### Application for Removal or Variation of a Condition following Grant of Planning Permission or Listed Building Consent

| Address Line 1 | <input type="text" value="Wanley Road"/> |

Construction of rear dormer extension with a Juliet balcony to provide additional living accommodation, together with the installation of three rooflights on the front roof slope, the installation of an air source heat pump to the side of the property and alterations to the existing windows and doors to the rear and side of the property.

23/AP/1789

PROPOSED ELEVATIONS

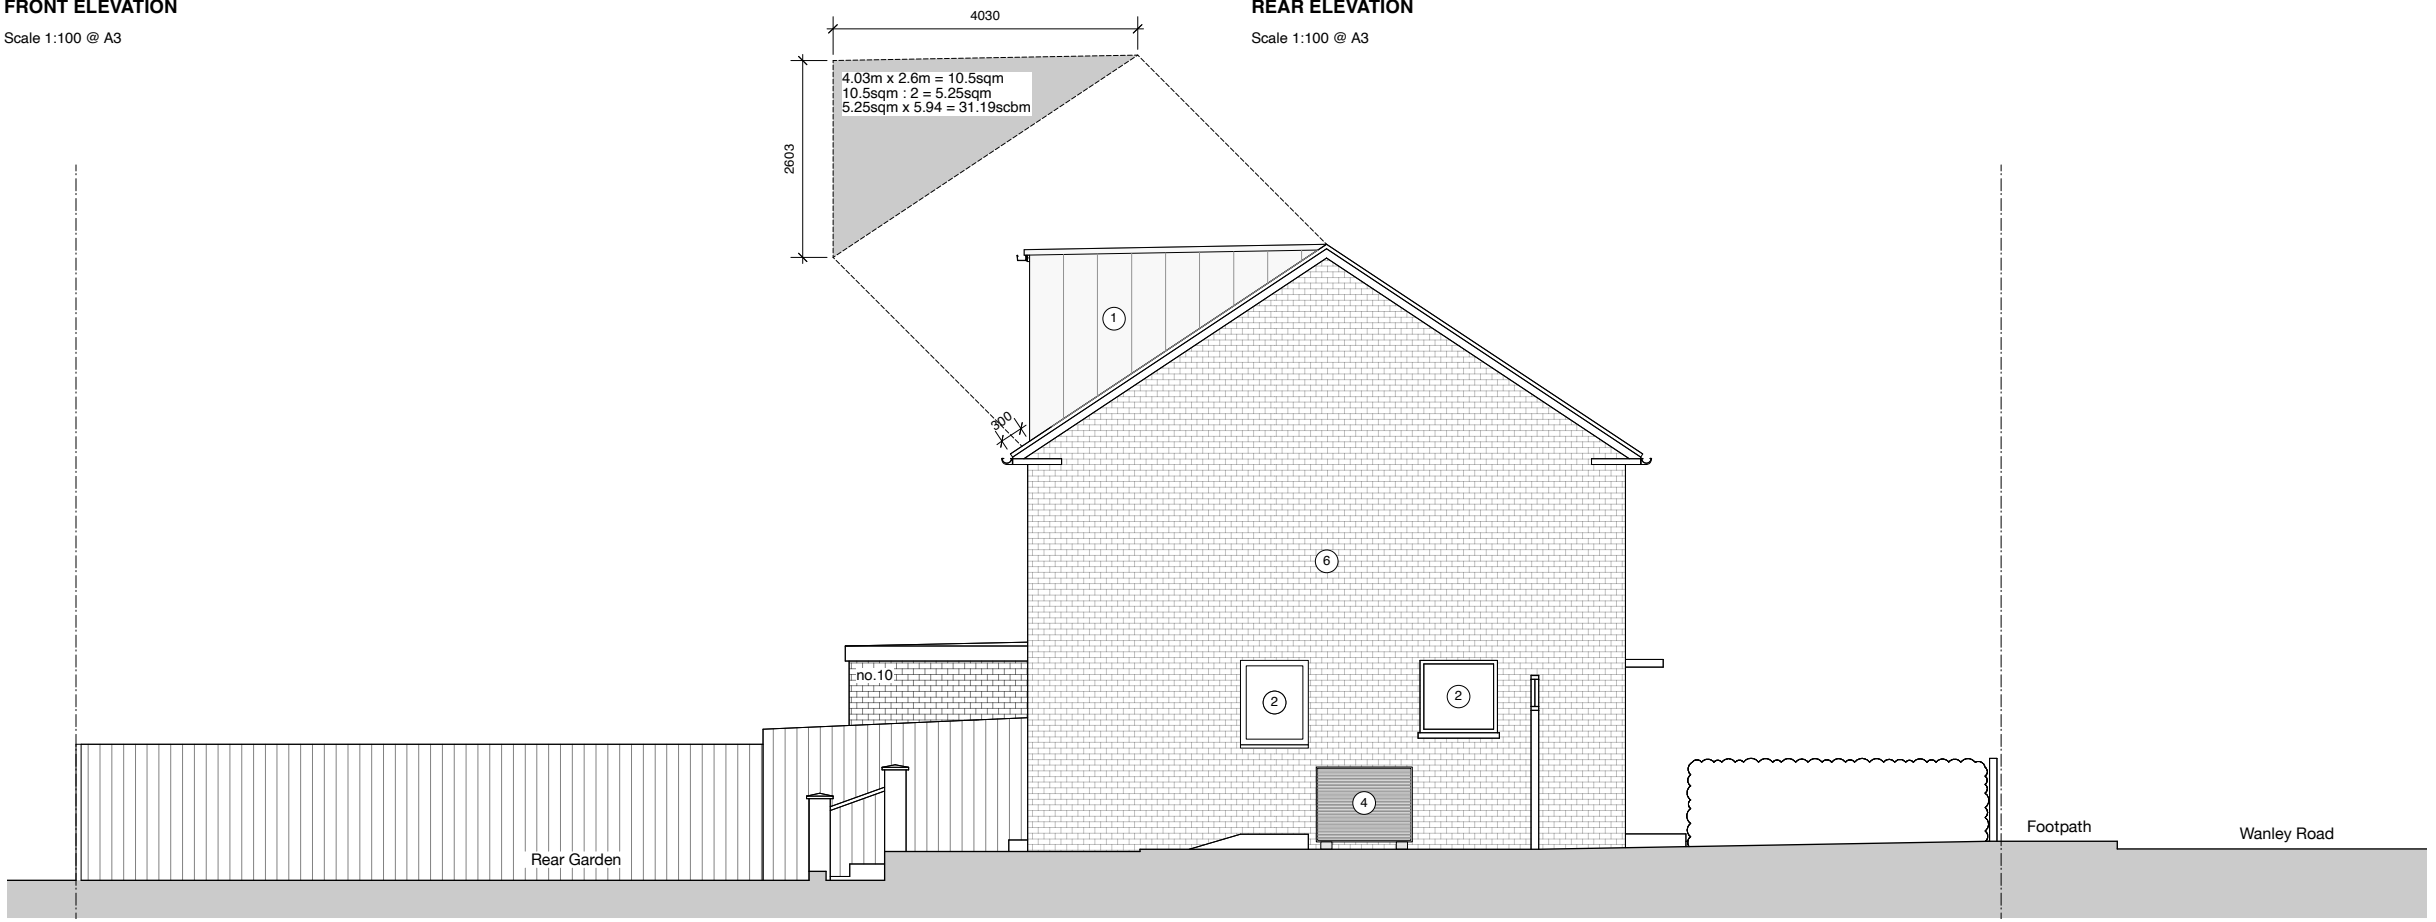
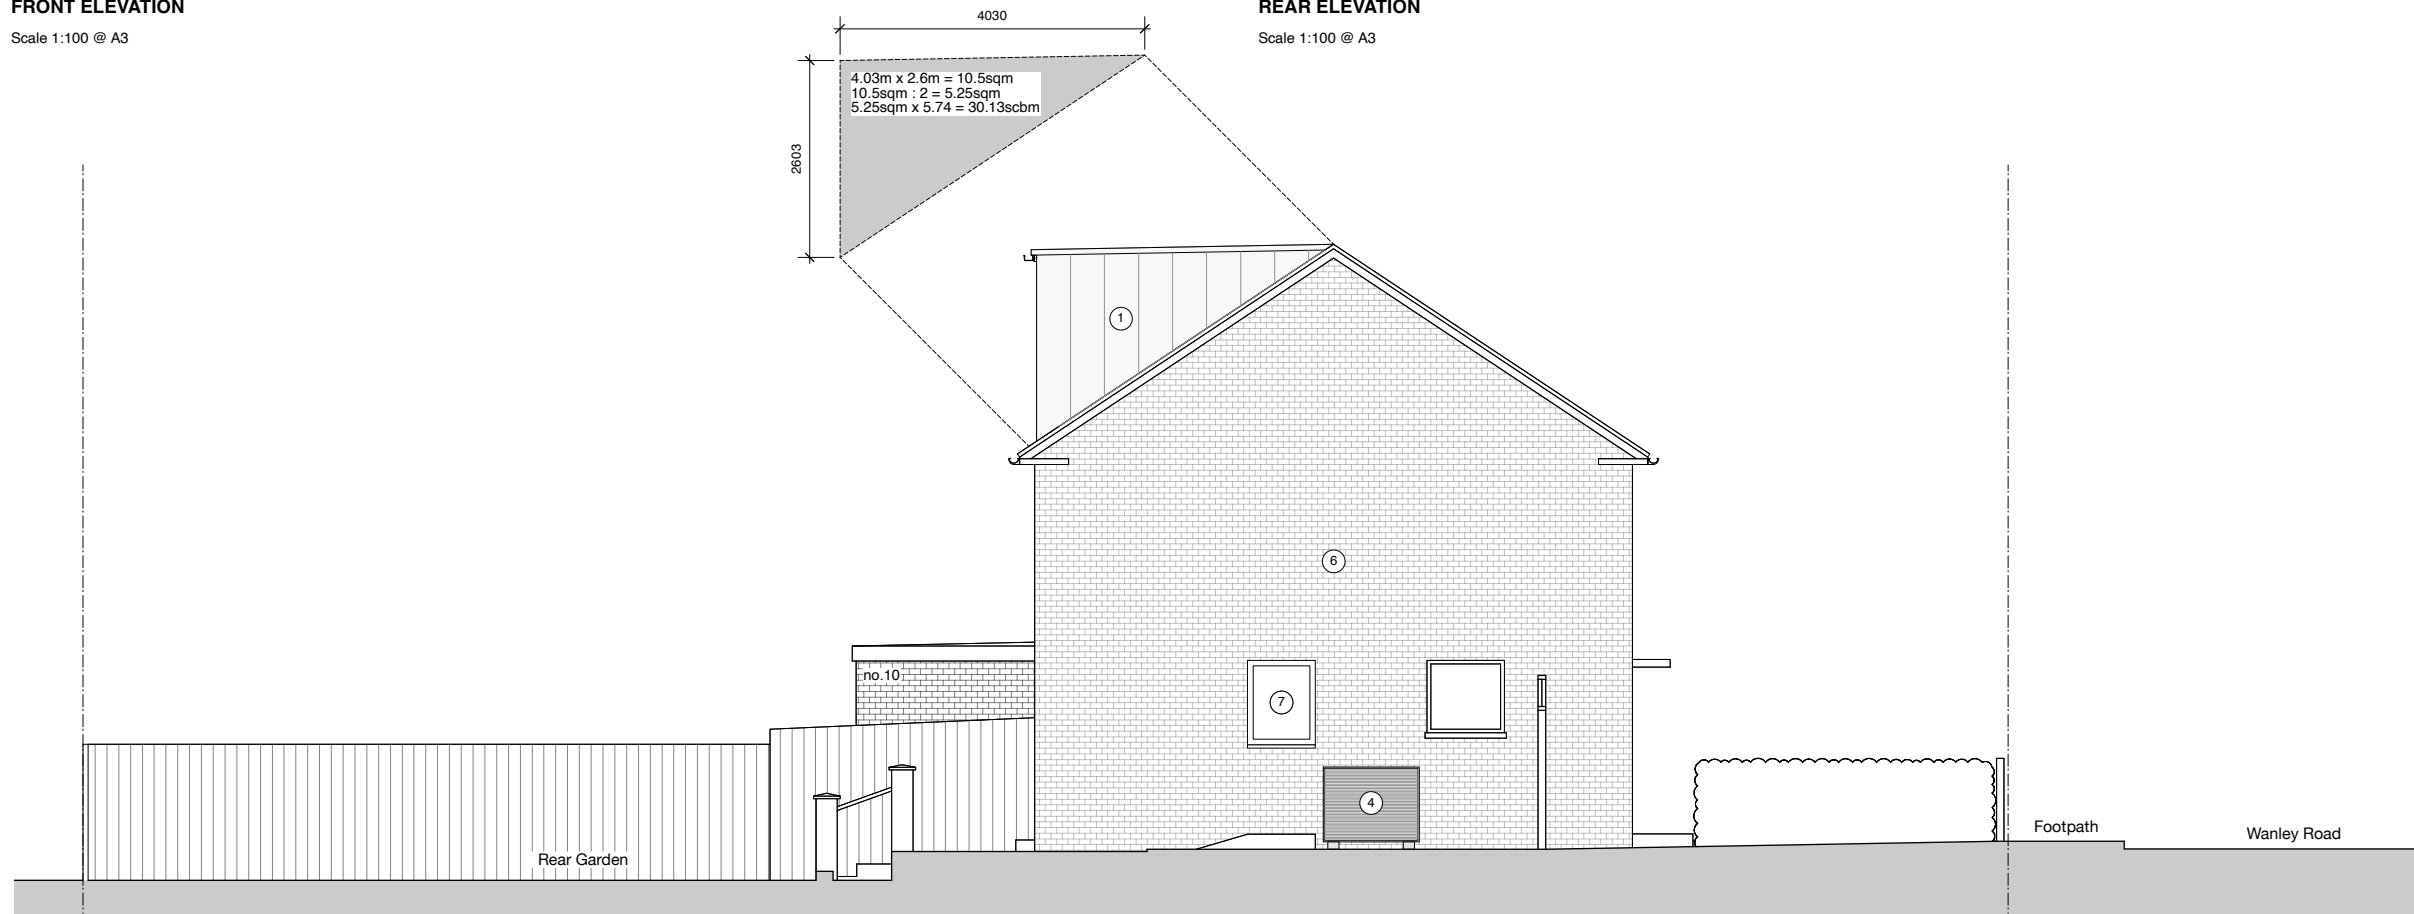
As narrow gaps in between roof dormers are highly impractical, increase thermal losses and pose a maintenance risk, the aim of the changed condition is to make it easier to build the structure, to reduce exposure to thermal losses and to mitigate maintenance issues in the future. Changes to ground floor fenestration - change from sliding into larger bifolding door on the ground for better daylight levels and connection with south facing garden.

Replacement of existing UPVC windows with matching units.

Change from timber aluminium windows to UPVC on rear and side elevation (ground) for more consistency with the other UPVC windows.

Drawings '9WR-01.001PL2 Prop floor plans' and '9WR-01.002PL2 Prop elevations' reflect the sought after changes to the ground floor fenestration and the top floor dormer.

DRAWING TITLE
PROPOSED FLOOR PLANS

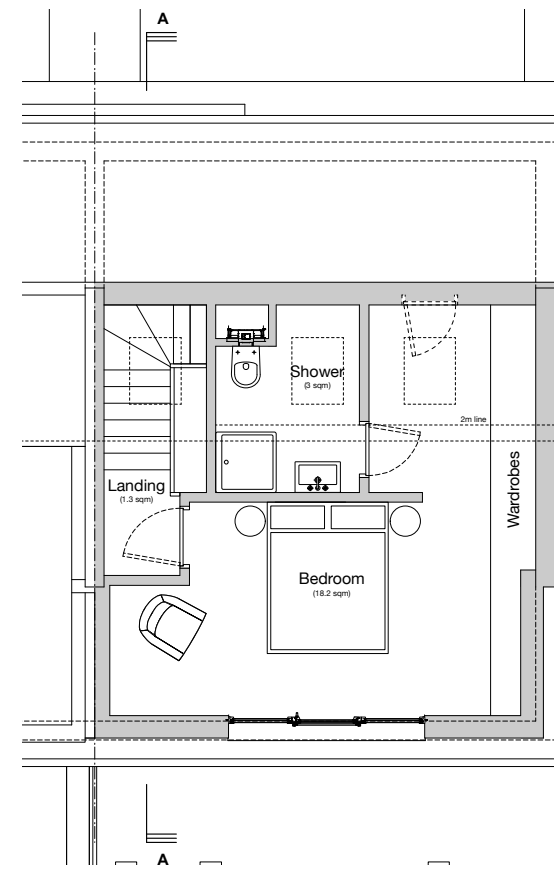
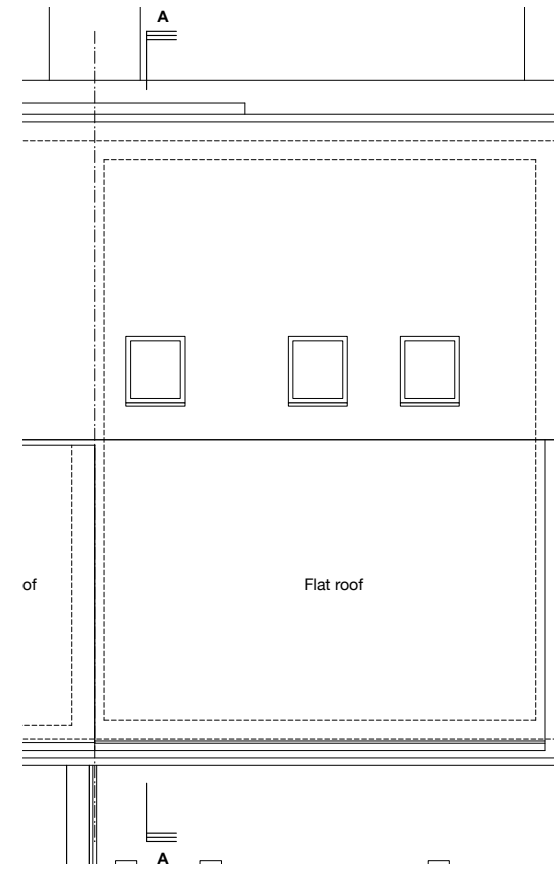
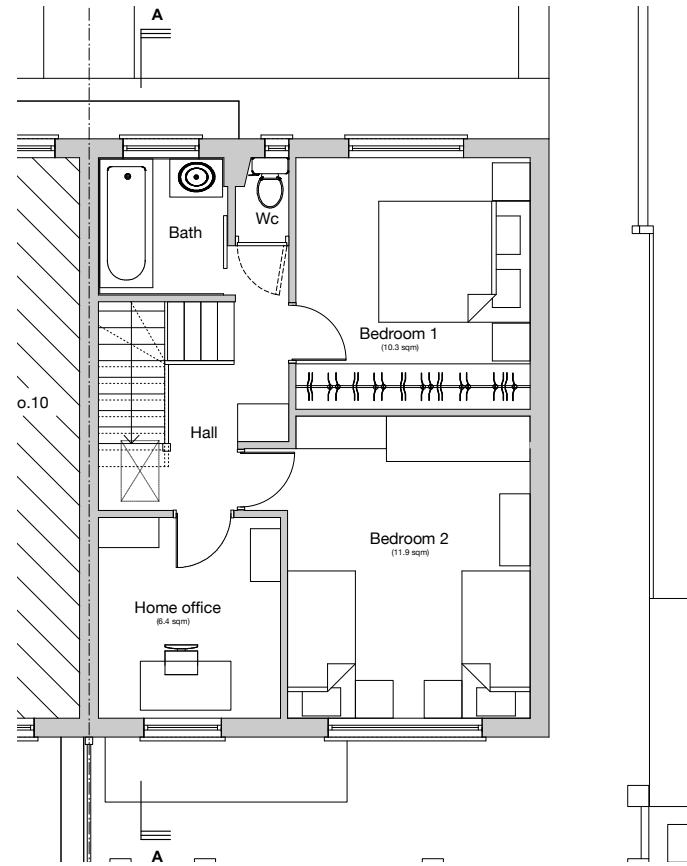
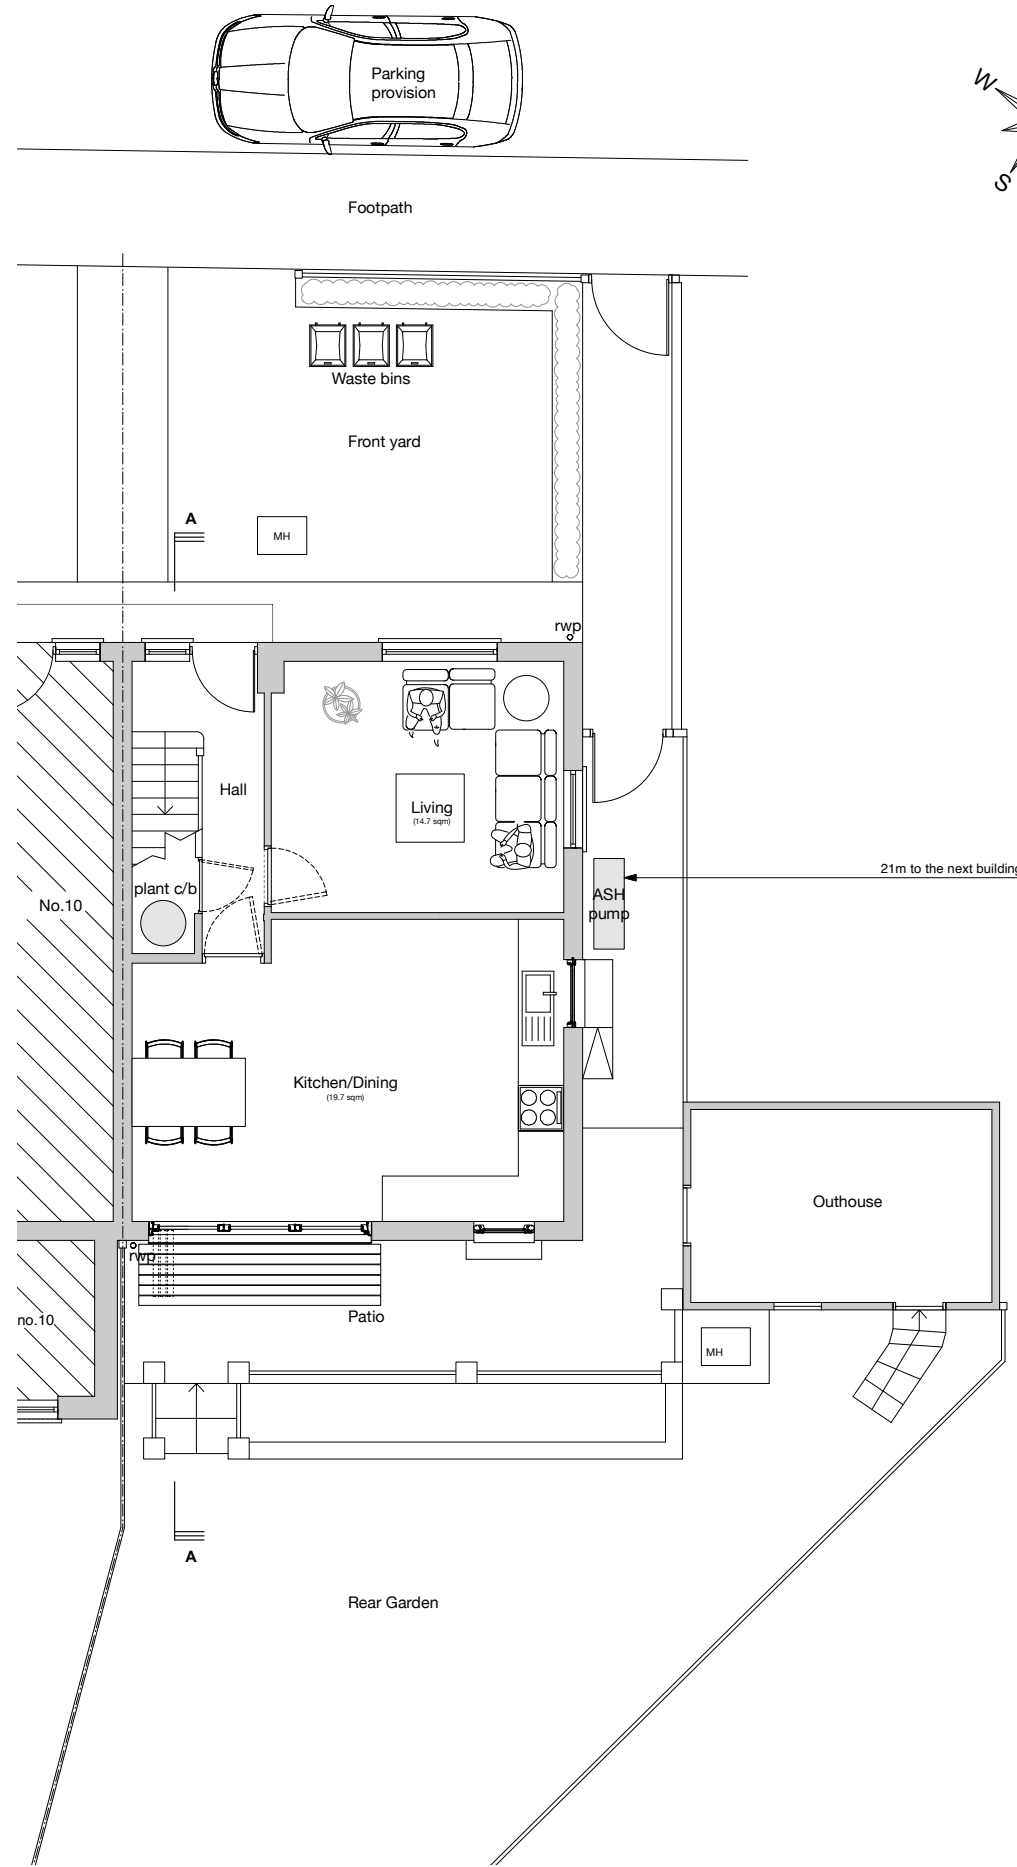
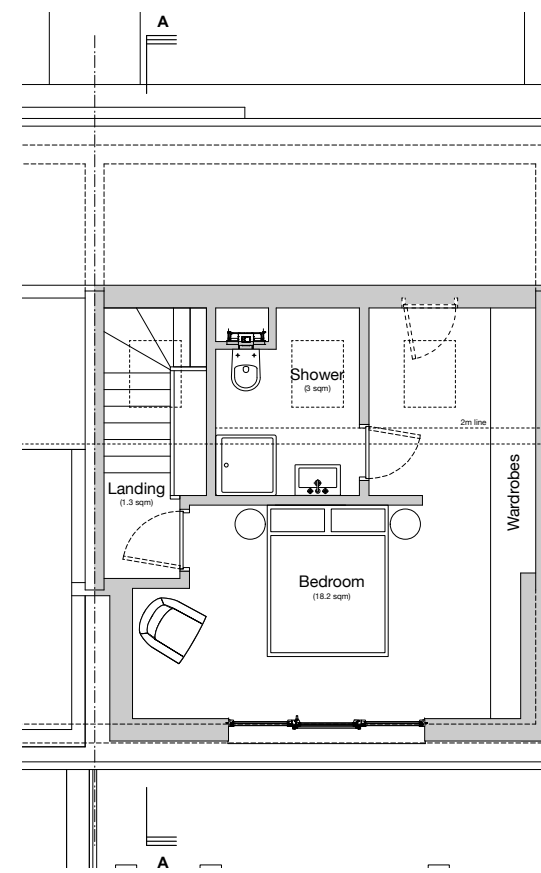
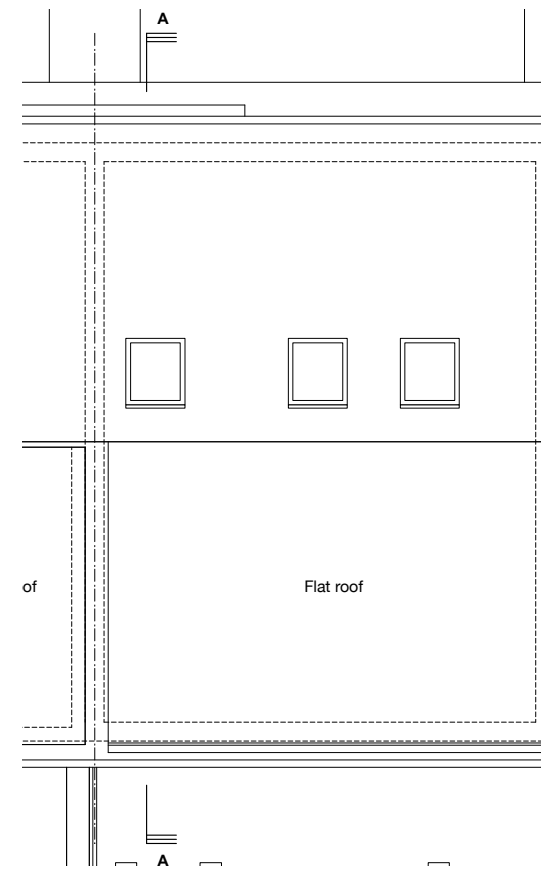
Change window configuration from three panes into sliding door on the top floor to reduce protrusions into the room.
